Further Ecology response

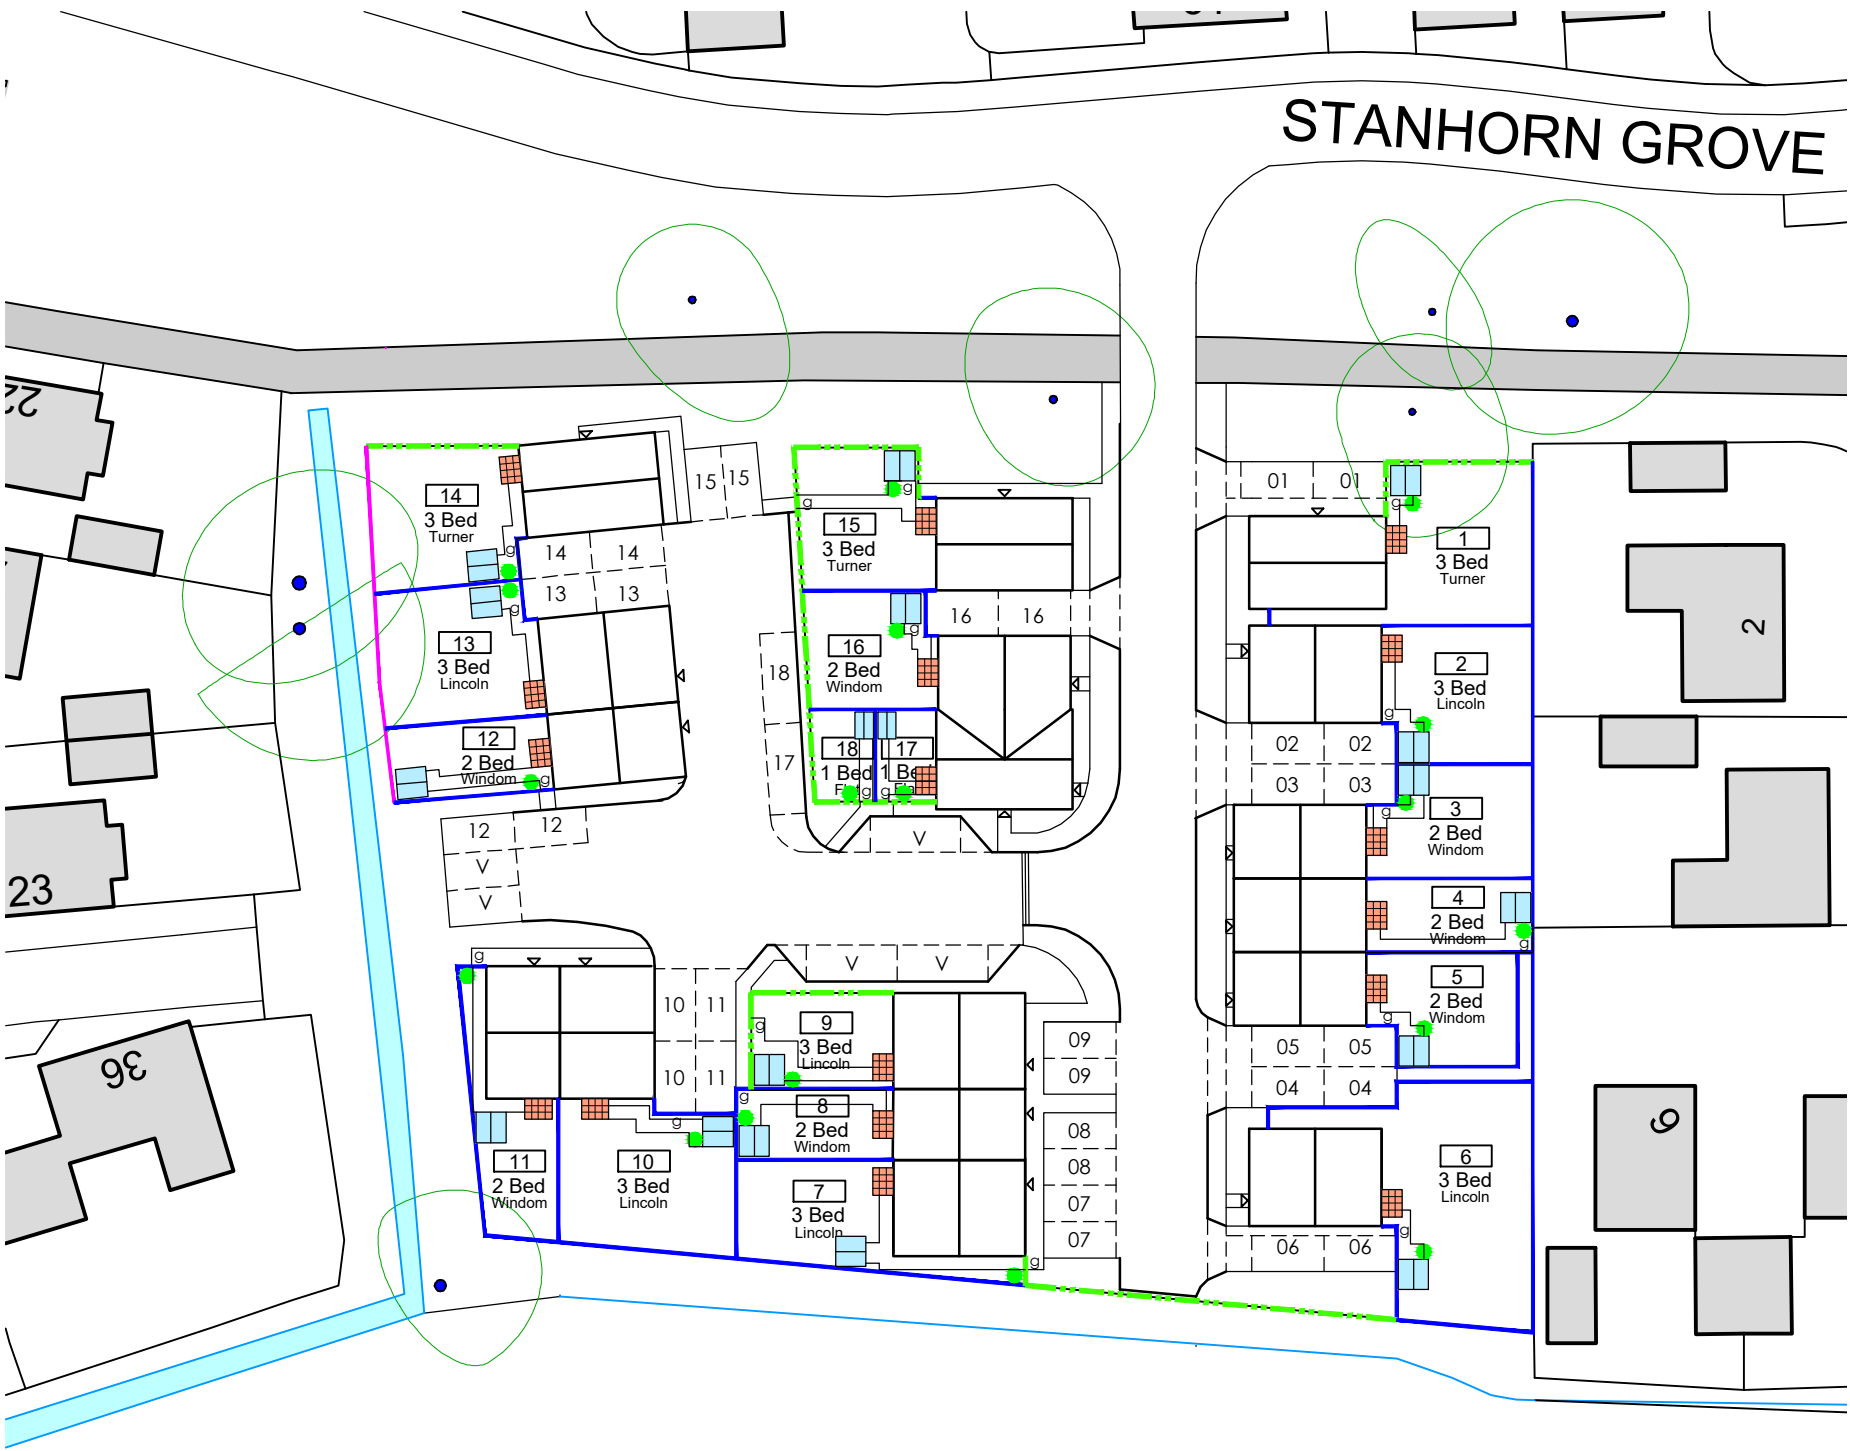
I am concerned that the lights proposed are still send light upwards. We tend to only approve directional lighting which is pointing downwards, and not towards any vegetation or building roofs etc.

Please see link below for external PIR lights. They are supplied by green lighting and are 8 watt LED, Activated by PIR so are not on permanently.

The 5 streetlamps and the fixed PIR lighting to dwellings has been designed with the ecology surveys in mind. I note the ecological assessment says a "sensitive lighting scheme" hence the minimal amount of columns. The report also states " Though several bat species take advantage of artificial lighting systems for foraging." And although the grassland provides a feeding ground for bats "the surrounding trees on site were considered to hold negligible potential to support bats due to lack of sustainable features" Trees have been retained however and enhancements made to not impact the bats however.
